Proposed Dargues Gold Mine Project Modification 2

I refer to the Environmental Assessment report for a proposed modification to the Dargues Gold Mine project dated July 2013, in which the proponent is seeking approval to modify the Project Site Layout and to amend the conditions of the Project Approval.

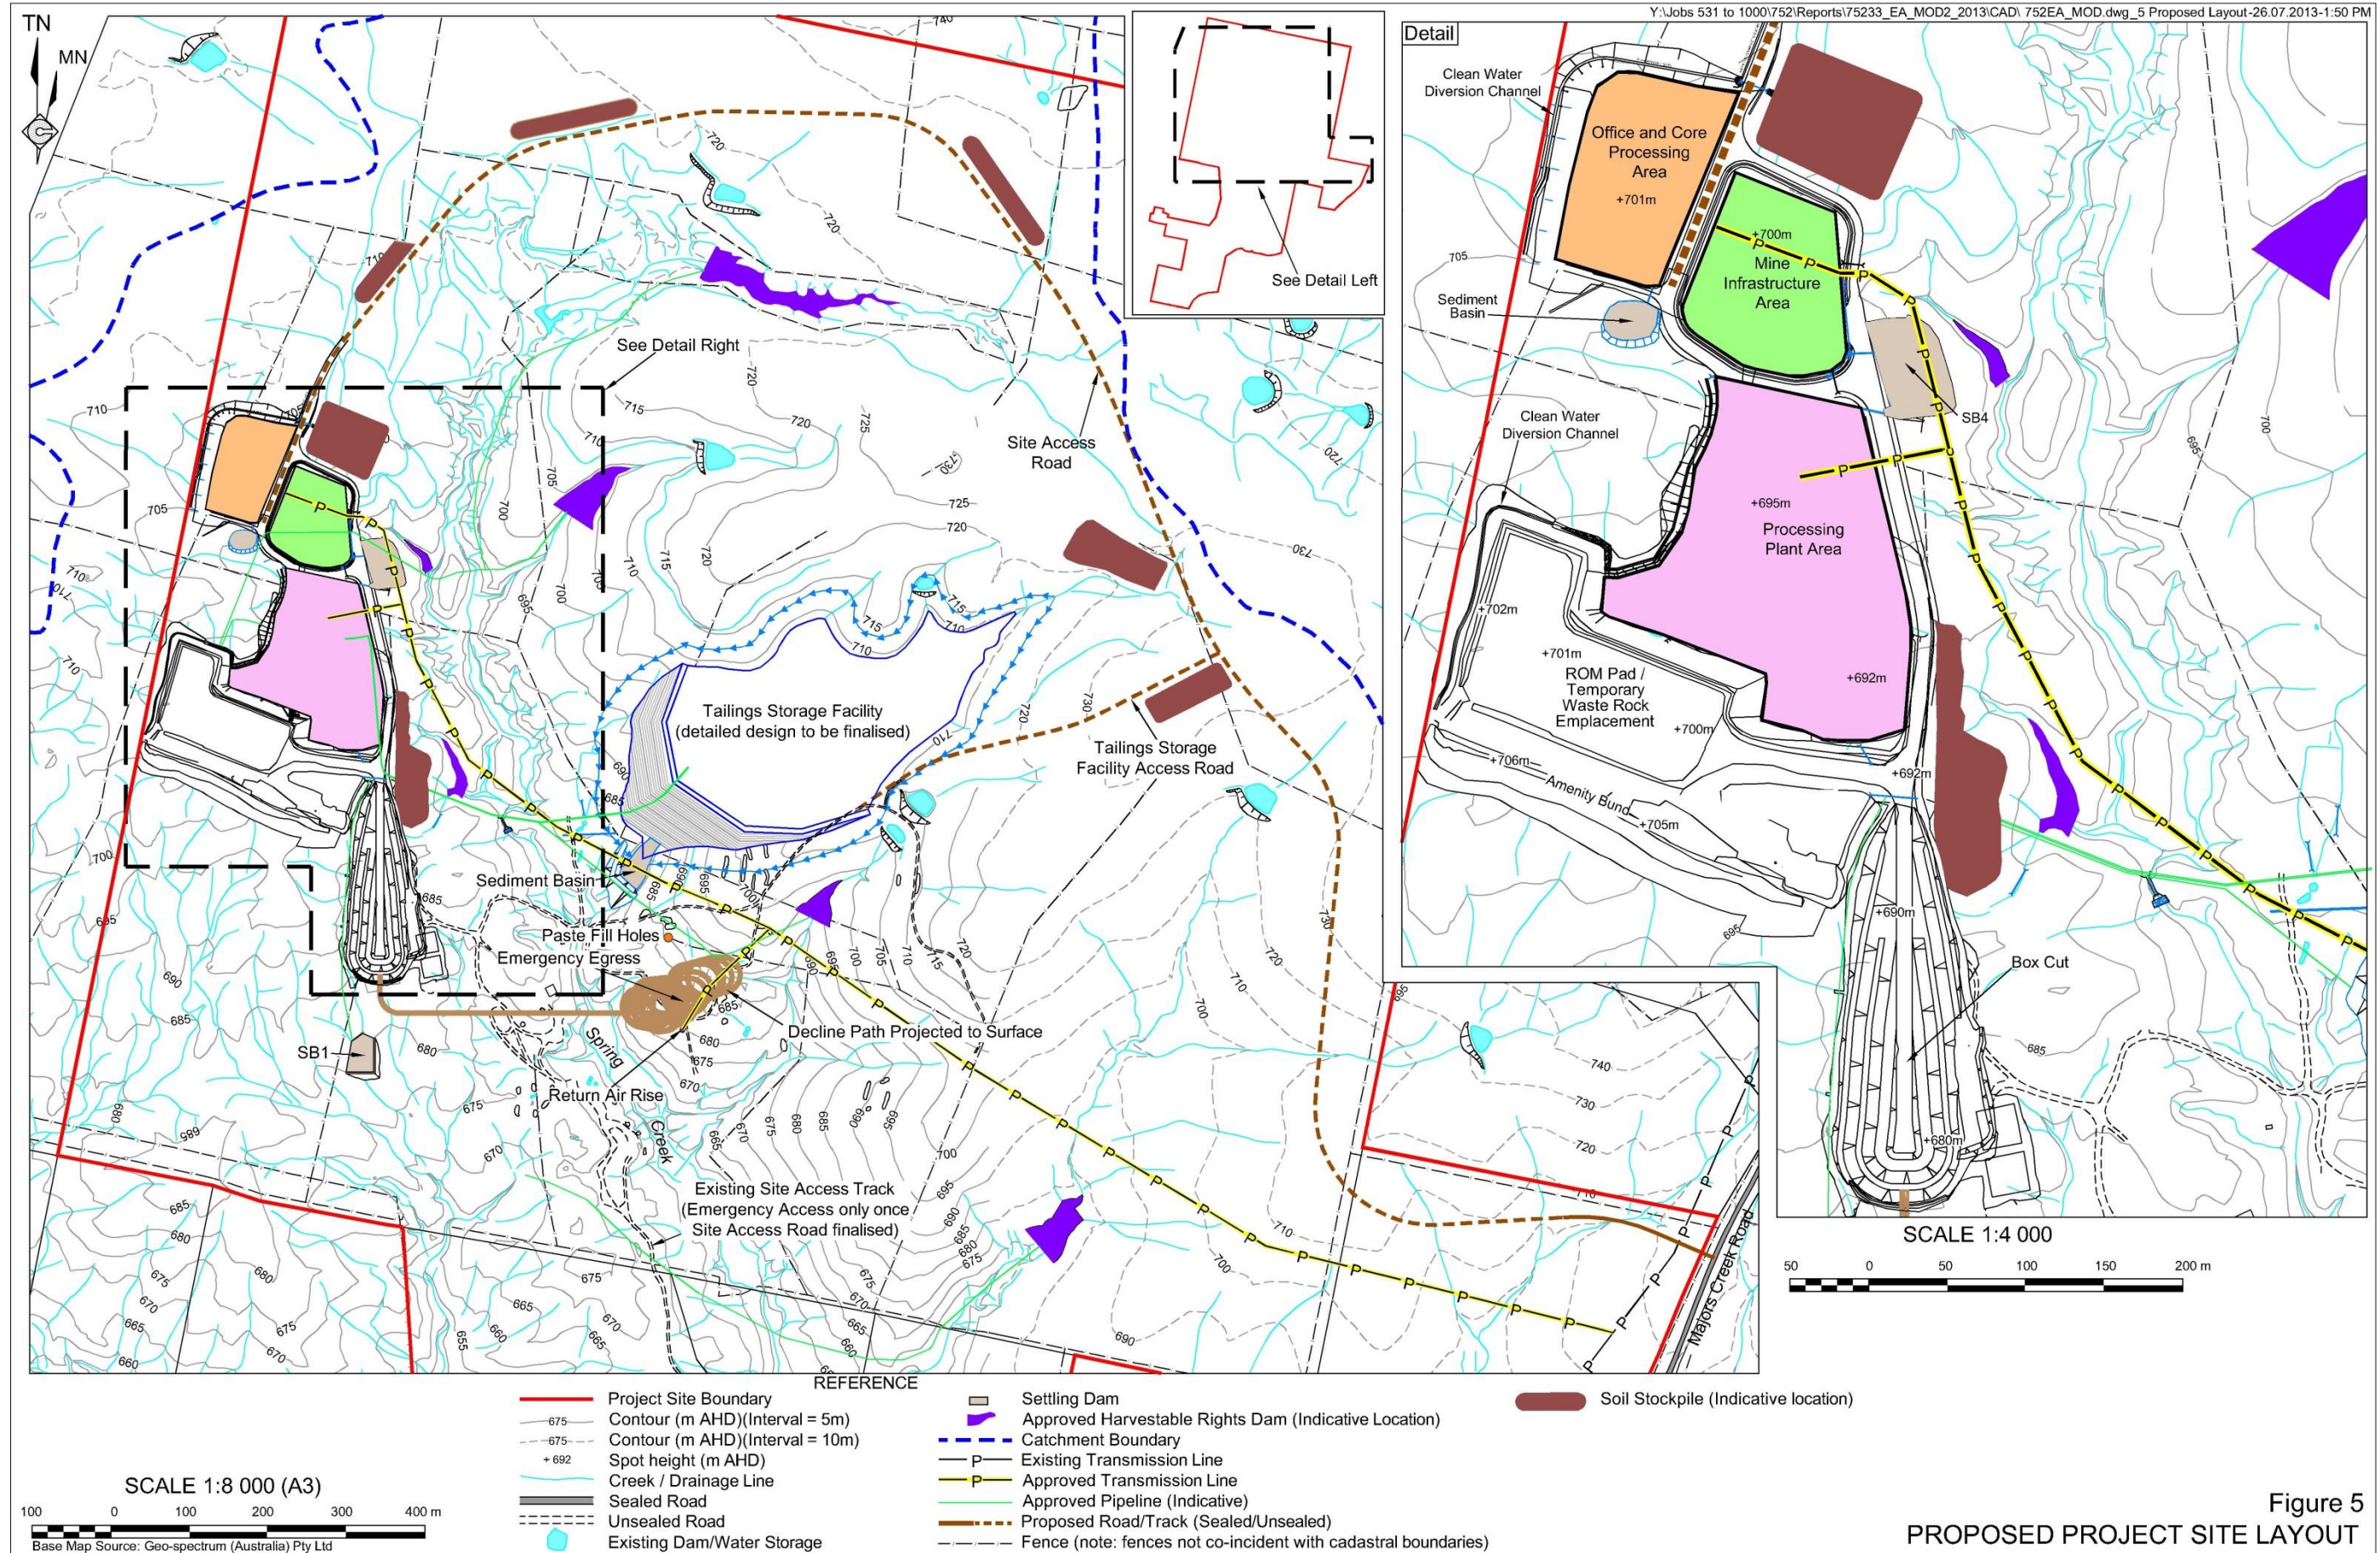
In the report the proponent notes that “the proposed modification does not include any additional infrastructure, merely modification of the location of infrastructure that has already been approved”. Council agrees that the proposed changes to the site layout are not in conflict with the intent of the Project Approval and has no objection.

As stated previously, Council does not object to site layout changes that are not in conflict with the intent of the Project Approval. If the intent of this proposed amendment is to allow further minor modifications to the site layout as the mine develops, I suggest that an exception clause be inserted into the Project Approval to accommodate this requirement.
